City of Albuquerque Stormwater Construction Site Inspection Report

ESC File No.	H10E033	Project Name:	2200 Vista Oriente		
NPDES Id. No.	NMR10036M	Location:	2200 Vista Oriente		
10/19/2023	Owner	Contractor			
Operator	Tuan Huynh				
Contact name & title	Tuan Huynh				
e-mail	tuanvhn@gmail.com				
Contact Phone #	505-269-1418				
COA Inspector	Chancellor English	Start/End Time:	1145am		
Construction Phase:	none, weeds and partial land disturbance				
Type of Inspection:	Regular	Storm Event	Post Storm Event >0.25"	311/Complaint	Follow Up
Weather at time of inspection?	Clear	Temperature:	~ 75		
Estimated date of last storm 0.25" or greater	9/14/2023

TEMPORARY EROSION AND SEDIMENT CONTROL PLAN

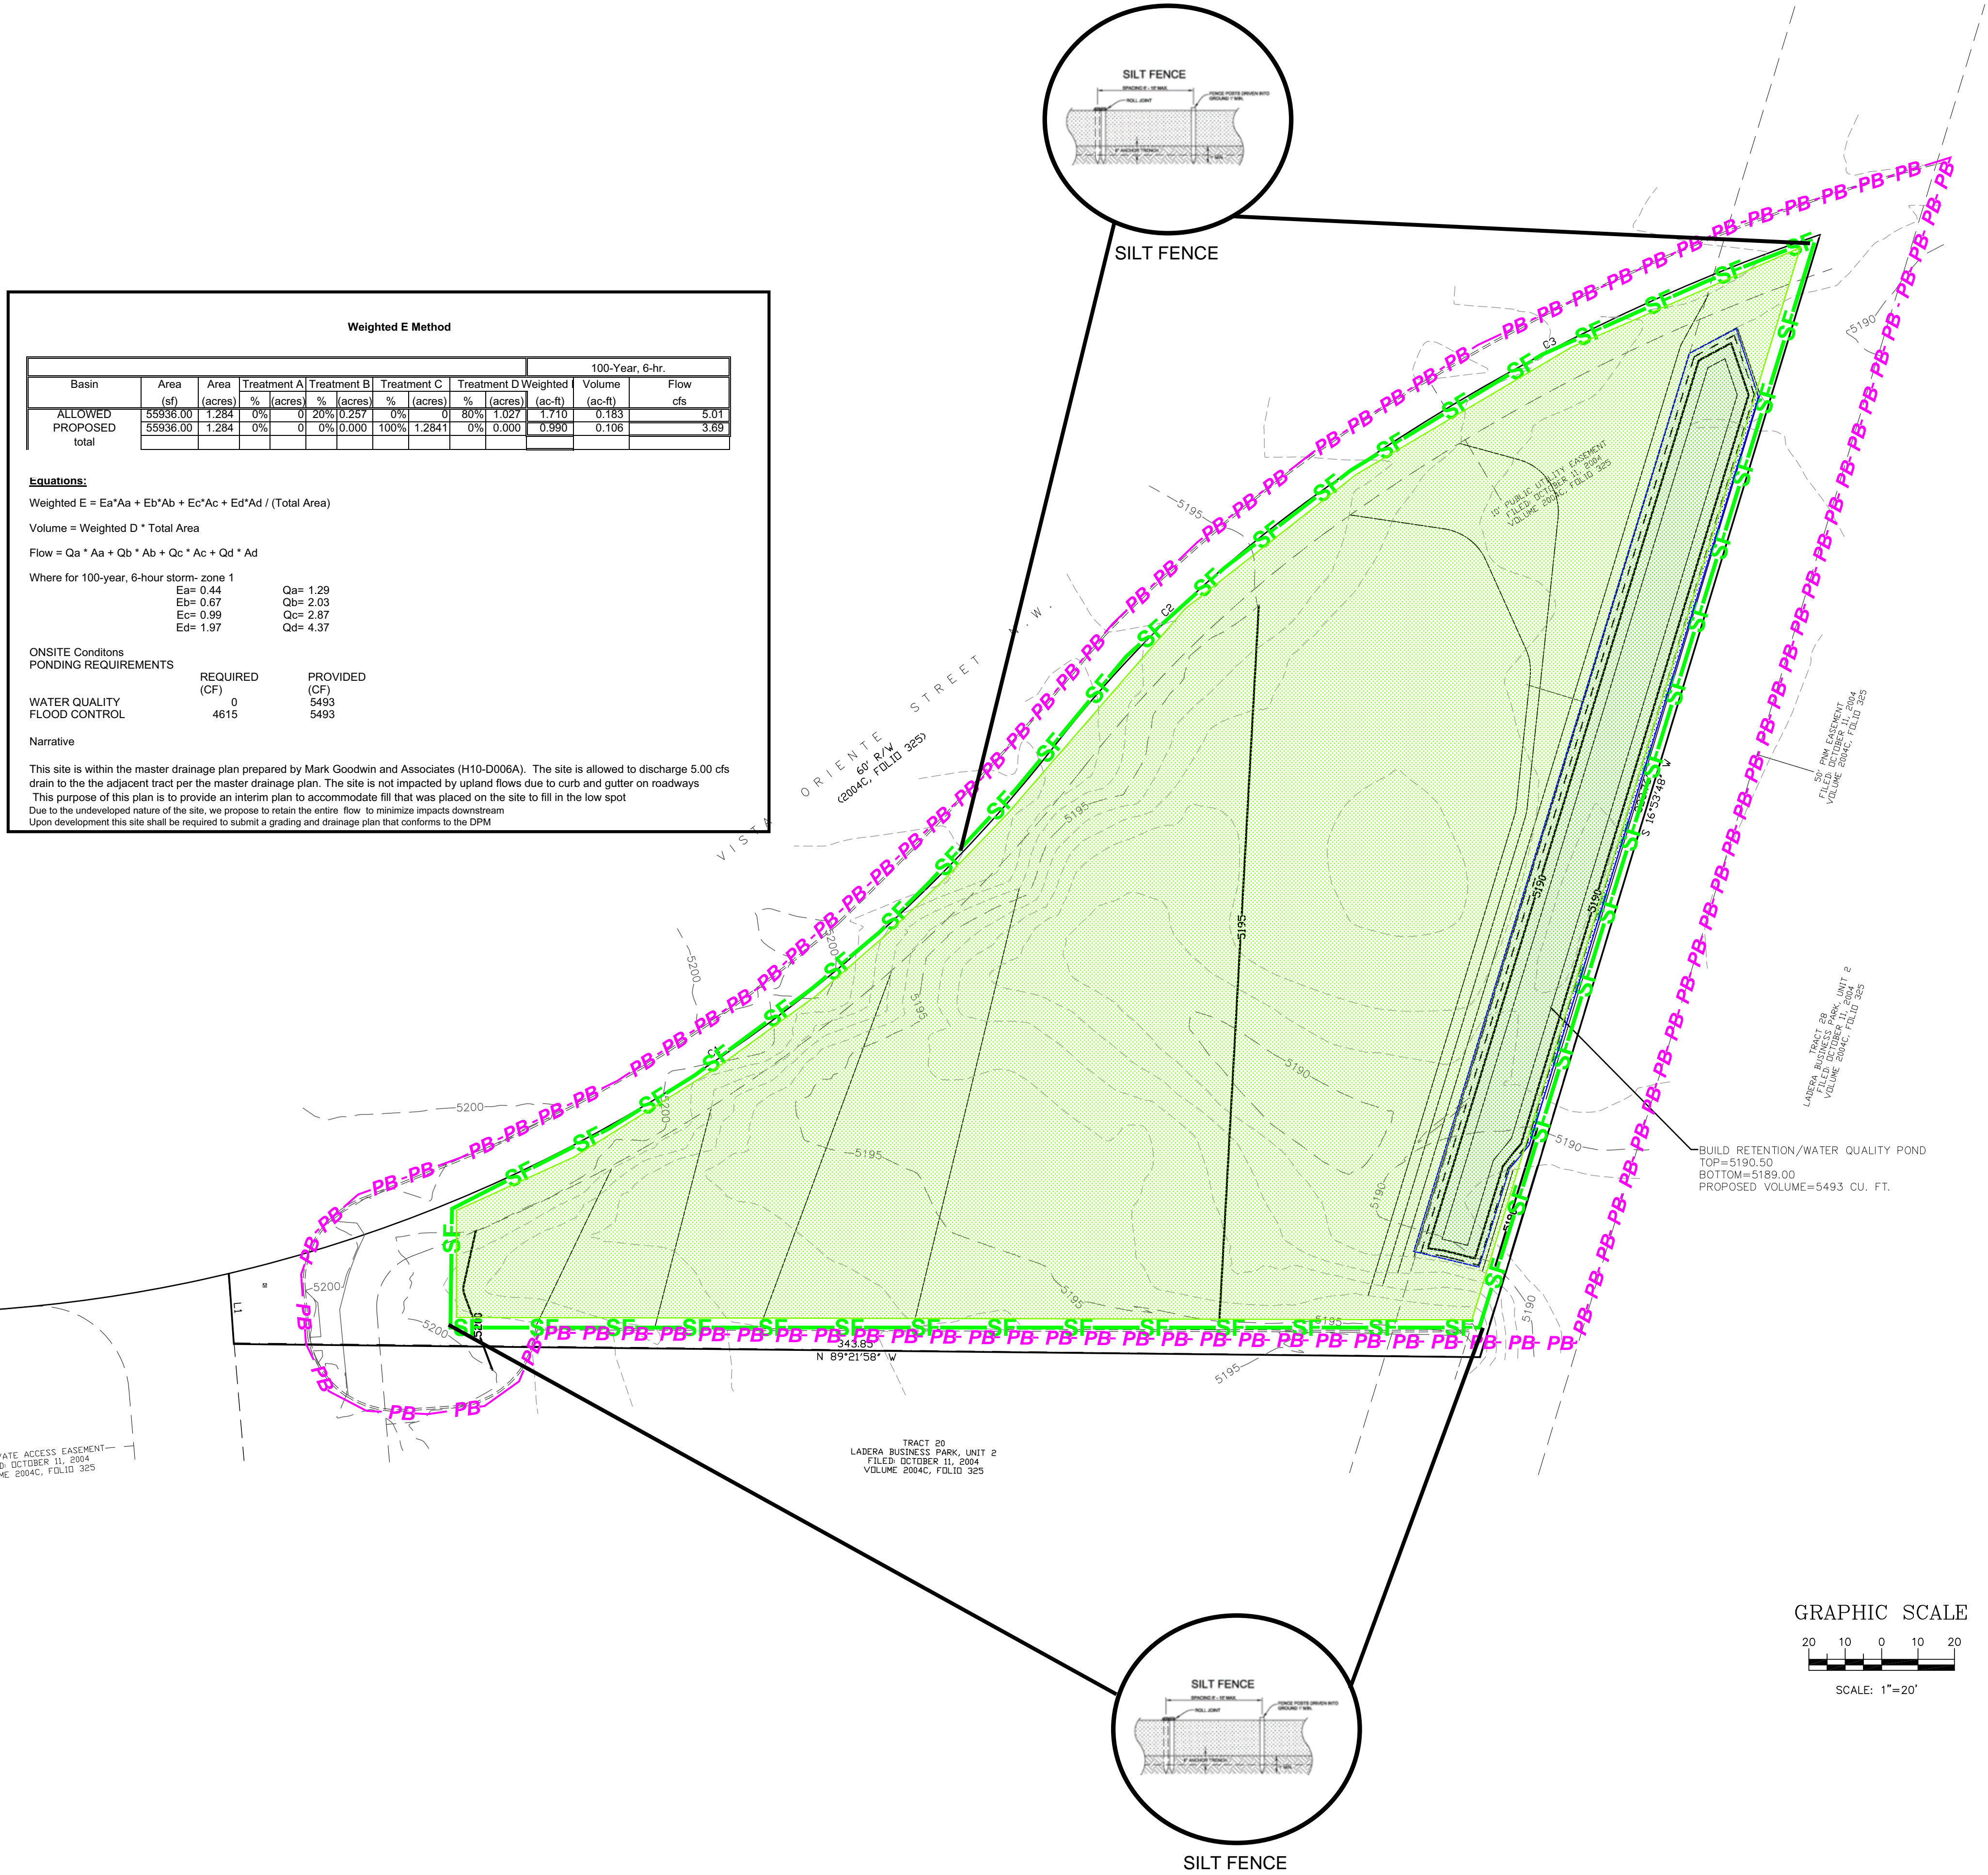
Item Number	Deficiency/ Corrective Action				
1	There was no CGP coverage posting and land has been disturbed in violation of CGP Part 1.5. Required mitigation: You must post a sign or other notice of your permit coverage at a safe, publicly accessible location in close proximity to the construction site per CGP Part 1.5.				
2	The SWPPP and self inspection reports were not available, nor was there a posting of the location if there is no personnel on-site in violation of CGP Parts 4.7.3 and 7.3. Required mitigation: You must keep a copy of the current SWPPP (7.3) and all inspection reports (4.7.3) at the site or at an easily accessible location so that it can be made available at the time of an on-site inspection. If an on-site location is unavailable to keep the SWPPP when no personnel are present, notice of the plan's location must be posted near the main entrance of your construction site. Please email the latest inspection report.

3	The perimeter silt fence has decayed and virtually non-existent in violation of CGP Part 2.1.4. Required mitigation: Ensure all stormwater controls are maintained and remain in effective operating condition during permit coverage per CGP Part 2.1.4.				
4	The site is still lacking compliant stabilization per CGP Part 2.2.14. The weeds are not sufficient vegetative cover and have become overgrown in violation of City Ordinance 9-8-4. The disturbed area needs stabilization. Required mitigation: Maintenance of weeds and stabilize the site if no construction activity for 14 or more calendar days as per CGP Part 2.2.14.
